SUBJECT: Response to “**SF-19-007– Midtown Collection at Hannah Ridge Filing 1 Second Submittal**”, dated September 9, 2019

MIDTOWN COLLECTION AT HANNAH RIDGE
FILE NO. 1
STREET IMPROVEMENT PLANS
SUN CHASER - ROSSA BELLE - CRACKER JACK

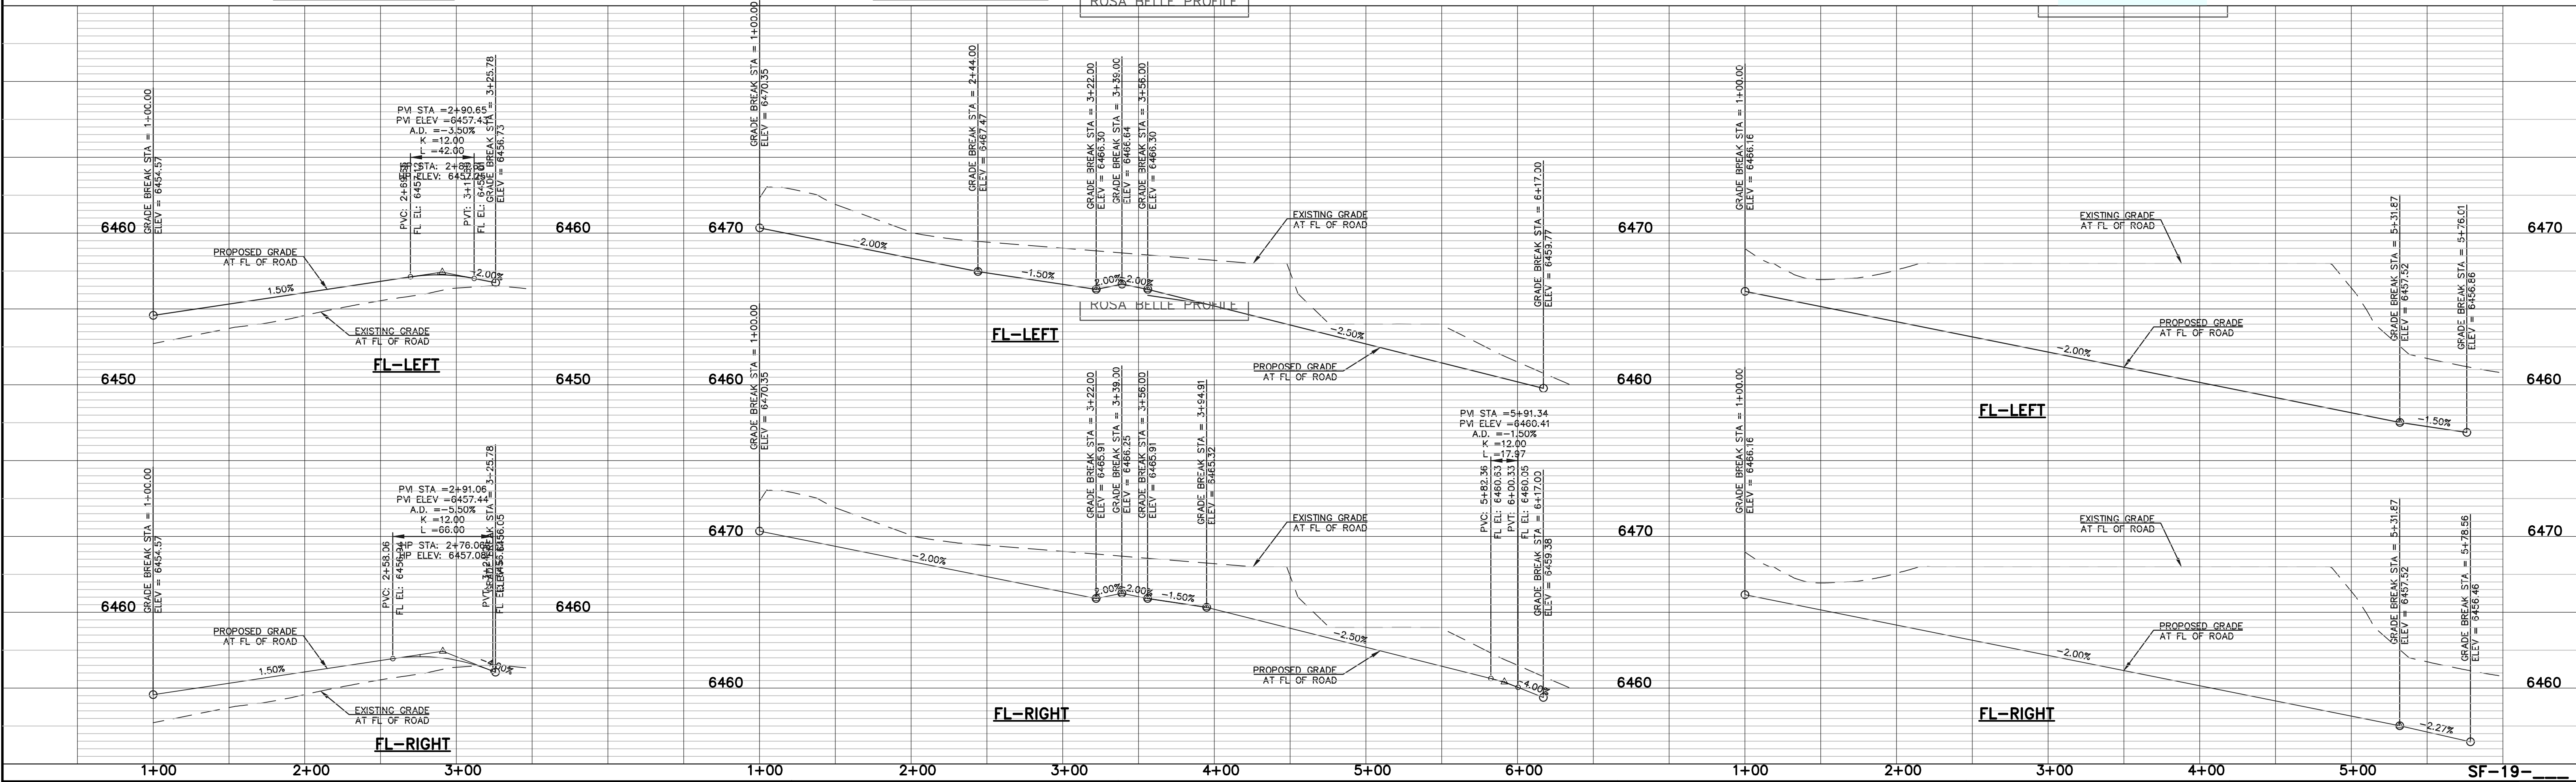
1. **Resolved.**
2. Provide street and pedestrian signage as appropriate for pedestrians along and crossing Constitution. Please discuss with Staff. **Unresolved.**
RESPONSE: Per meeting with county, crossing of Constitution is only viable further west away from the site until the signal is warranted and installed.
3. **Resolved.**
4. **Resolved.**
5. Show and label permanent BMP maintenance access roads on the plans. **Unresolved, See redlined plans.**

RESPONSE: BMP access roads coordinated with EPC recommendations. Revised as shown.
